Subject: 2021/1089 Barnsley West (Employment)

Here are the urban design comments on planning application 2021/1089, for the employment proposal for Barnsley West, following the amendments dated October 2023. Apologies for the delay in sending.

Parameter Plan	
Originator project ref 19028	Purpose of Issue PLANNING SUBMISSION
Scale(s) 1:2500	Status S2 SUITABLE FOR INFORMATION
Paper size A1	Revision P08 PRELIMINARY

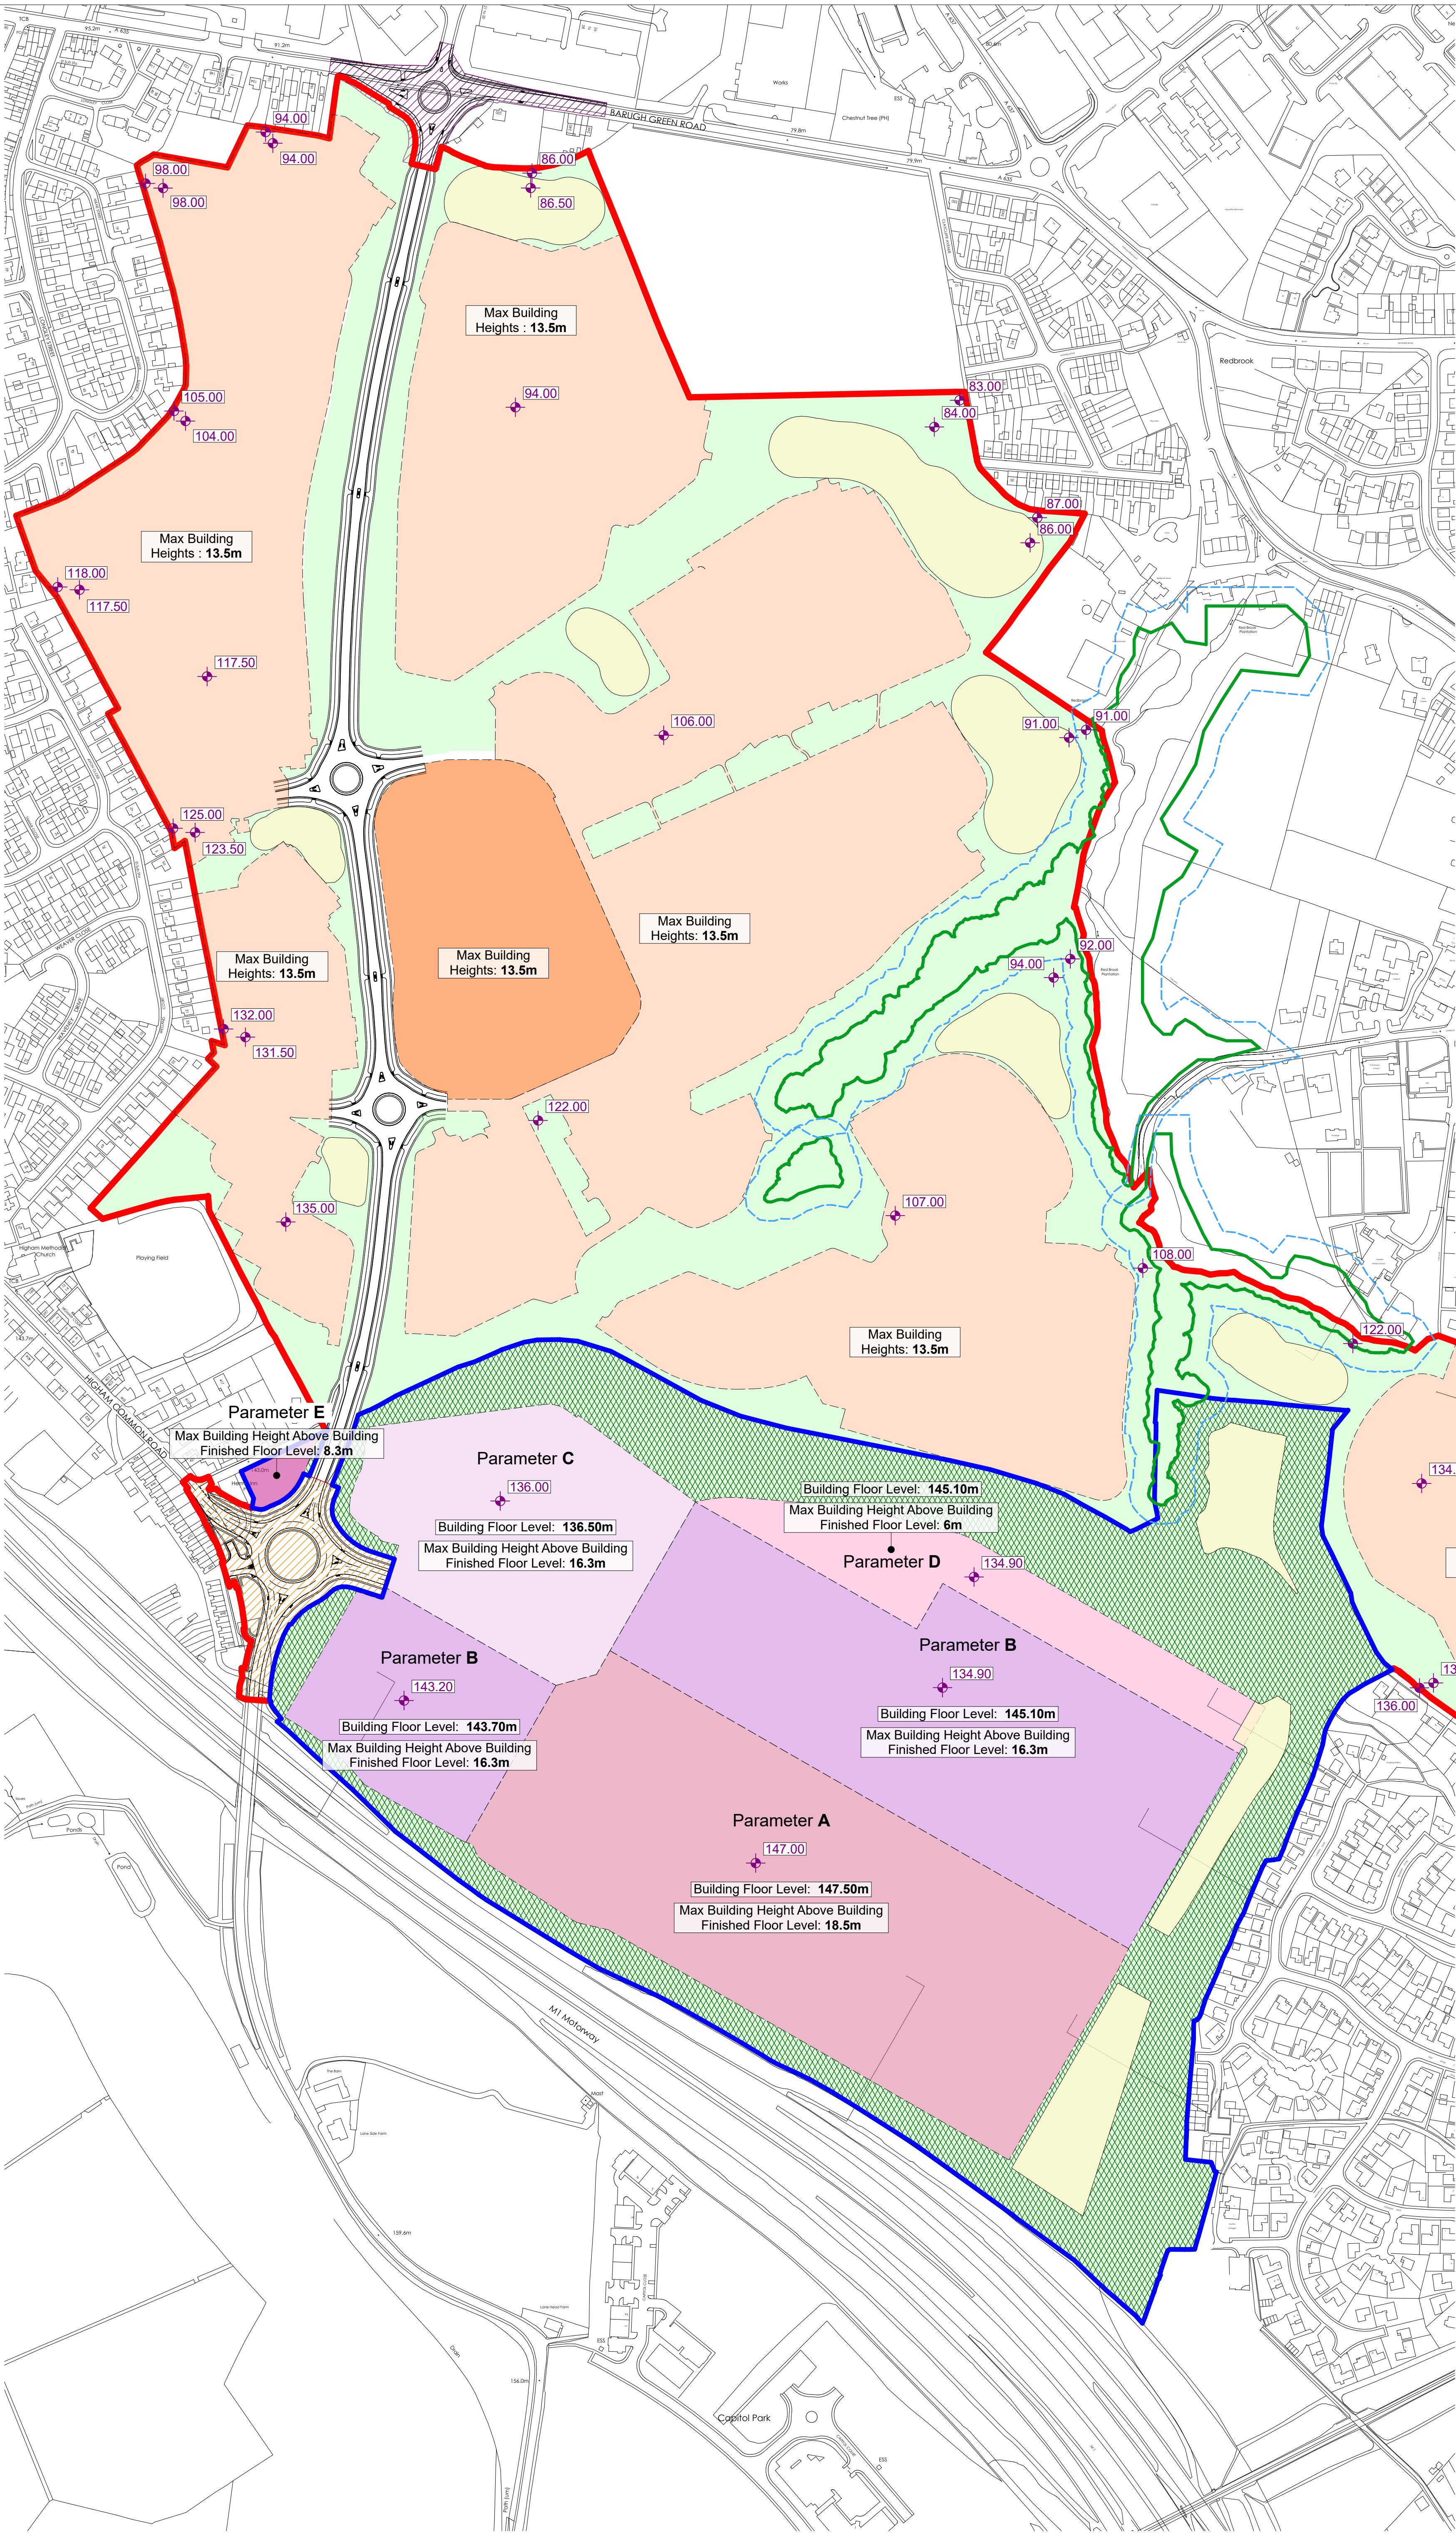
The indicative 3d images of the employment units show a mix of mainly horizontal and some vertical stripes on the elevations. I am not convinced that the vertical stripes help to reduce the impact of the height and scale of the structures. I think staying with a horizontal emphasis would be more effective. I note from the long range landscape view looking from the north, towards the structures, that the combined effect of several employment units located next to each other is a quite an elongated, long horizontal mass. I also note from this view that the top of the employment units can be seen below the horizon line. This leads me to suggest that a strong emphasis on horizontal banding is the best way forward, ensuring that the top-most colour is not too light in shade. I think it would be worthwhile to further explore colour and striping, (for example, perhaps having horizontal stripes of different heights and widths), before any reserved matters application regarding appearance is submitted.

Please can we ensure a high density of tree planting for the strategic landscaping, including on the northern boundary facing the residential character area of 'velvet village' and to the boundary to the M1, to help reduce the visual impact of the scale and height of the employment units.
